Our Case Number: ABP-322154-25

An
Coimisiún
Pleanála

Date: 15 July 2025

Re: For a period of 10 years for a development at the site. The development will consist of the provision of 7 no. wind turbines, and all ancillary works and apparatus. An Environmental Impact Assessment Report and Natura Impact Statement has been prepared in respect of the proposed development and accompany this application.

Figure 1 Cumulative Predicted Noise Contours

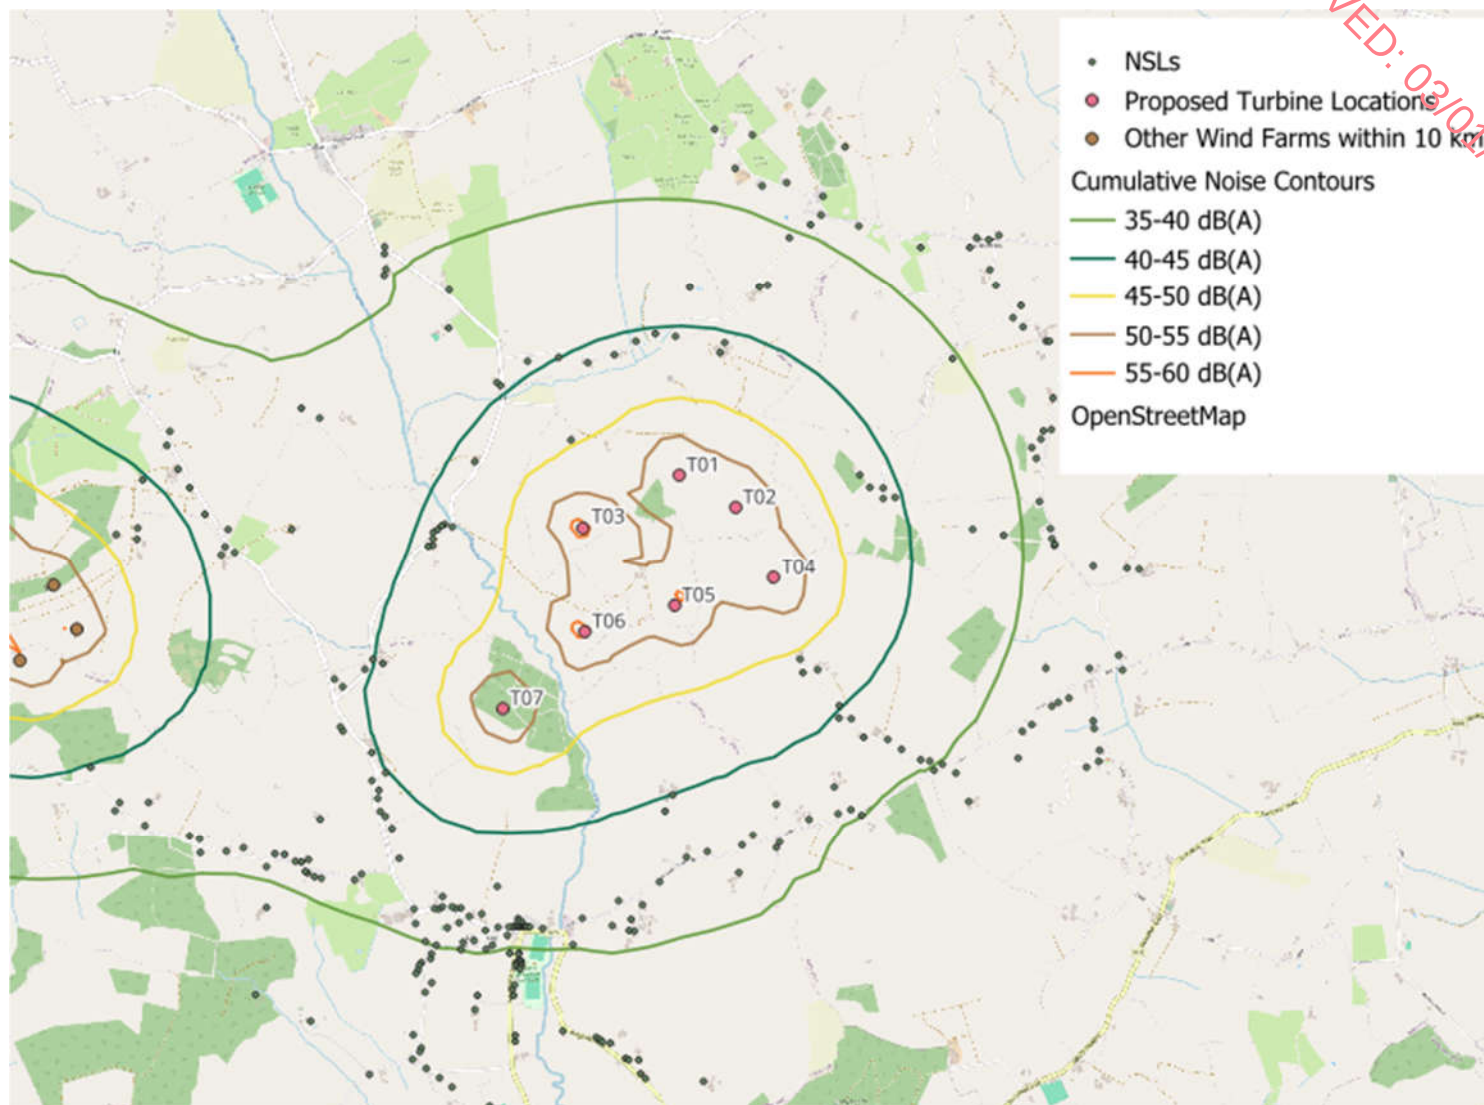
4. It is acknowledged that you have submitted a map of the study area which shows the predicted cumulative noise level contours at 9m/s wind speed (i.e. Appendix A of Appendix 3 of the First Party Appeal prepared by Awn Consulting) and all NSLs included within Appendix 12-7 (Predicted Cumulative Noise Levels) appear to have now been identified. From a review of the study area map, it is noted that NSL 270 & 275 are located within the 40dB(A) contour associated with the Foyle Wind Farm. However, a predicted noise level of 35.9dB(A) and 35.3dB(A) has been indicated at these NSLs respectively at 9m/s within Appendix 12-7 of the EIAR. You are therefore requested to clarify these apparent discrepancies.

Option D Standard Horizontal Directional Drill Under Existing Watercourse Crossing

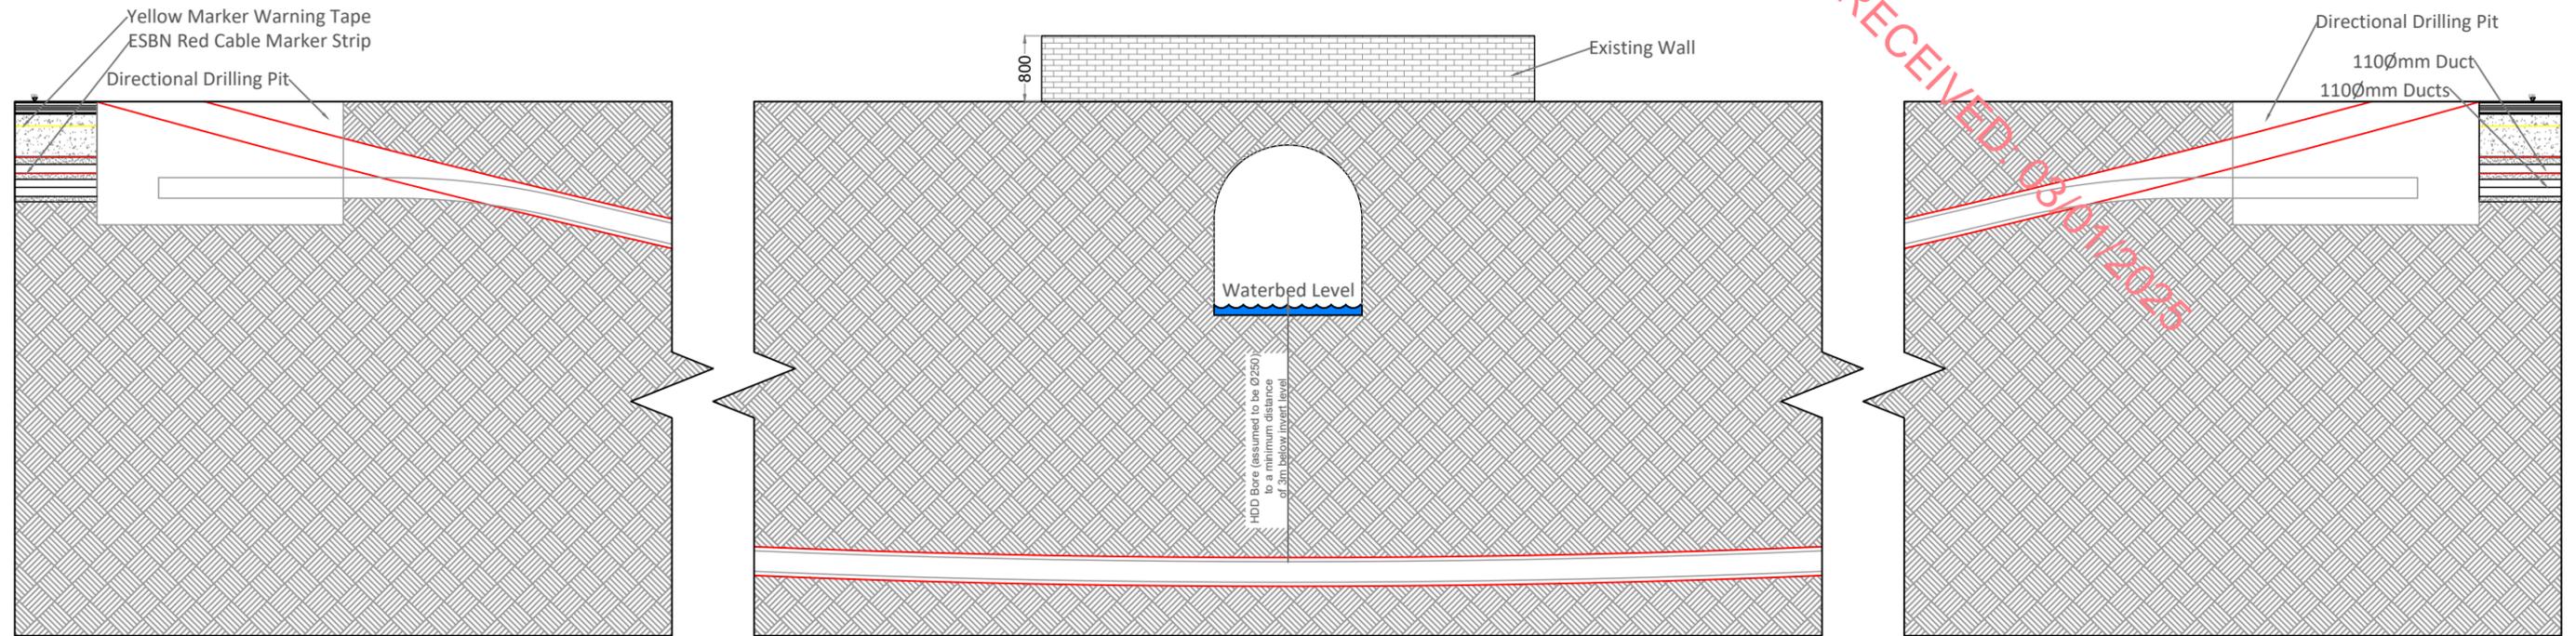
4. You are requested to submit a detailed site layout plan for the crossing of the River Nore where HDD is proposed. The submitted plan shall clearly identify the locations of the launch and reception pits on either side of the river along with details of all the proposed mitigation measures. A similarly detailed layout plan shall also be provided for all other locations where HDD is proposed along the grid connection route.

Figure C: OPW Past Flood Events Map

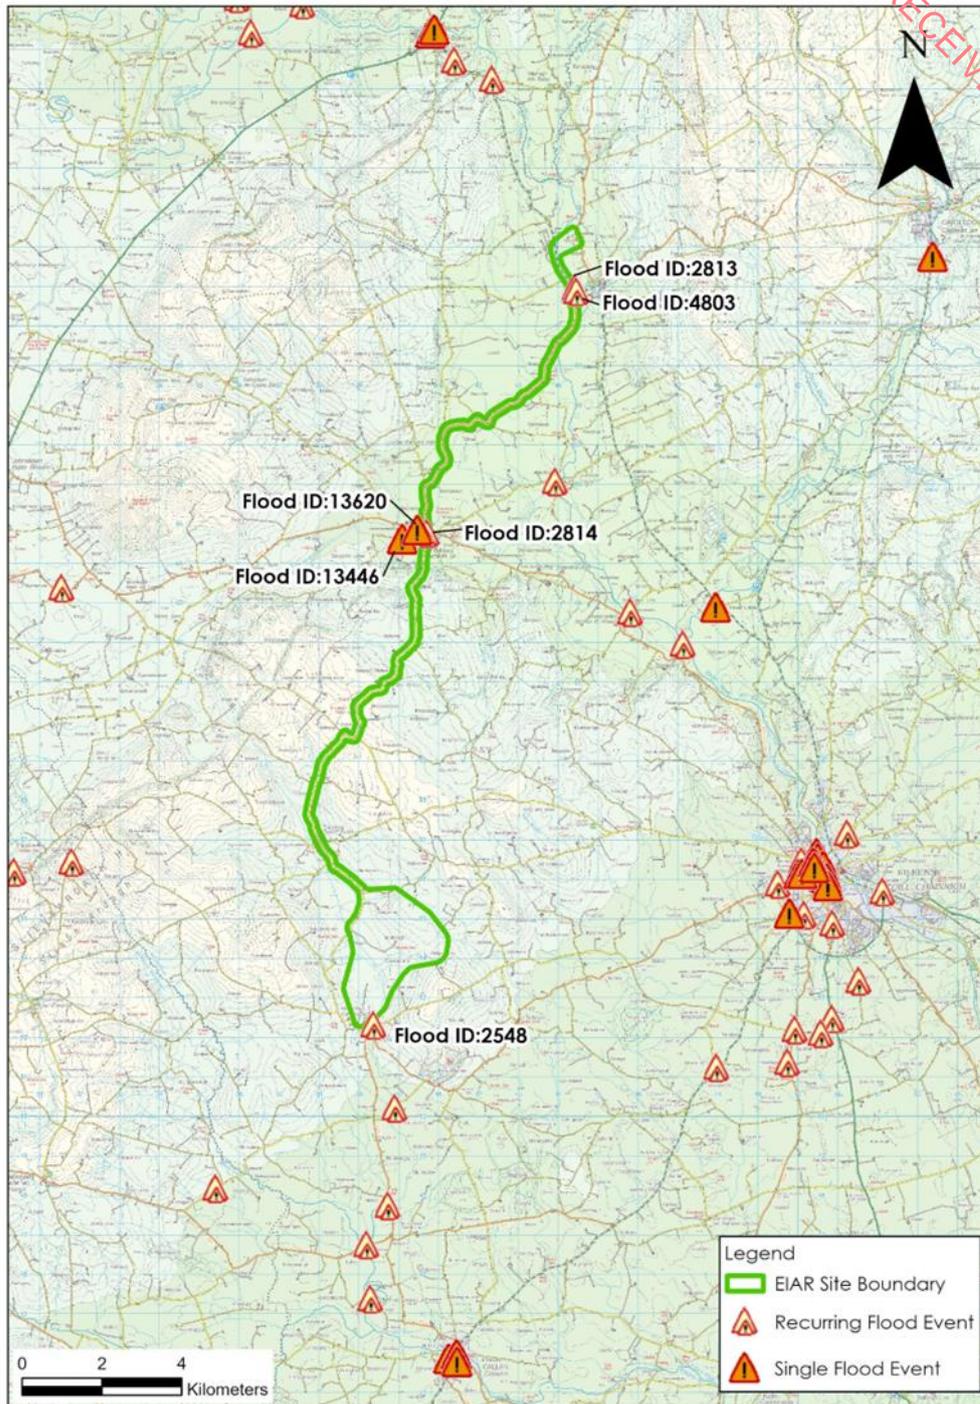
5. It is noted that the crossing of the Tullaroan Stream and some access roads are proposed to be located within a flood zone (National Indicative Fluvial Mapping). In addition, there is a history of flood events immediately downstream of the site within the village of Kilmanagh. In this regard, you are required to submit an updated Flood Risk Assessment (FRA) which includes detailed site-specific hydraulic modelling of the Tullaroan Stream which should examine the potential impact on the existing floodplain or on flood risk elsewhere downstream. The updated FRA shall also have regard to the alterations that have been undertaken to the Tullaroan Stream within the boundaries of the site.
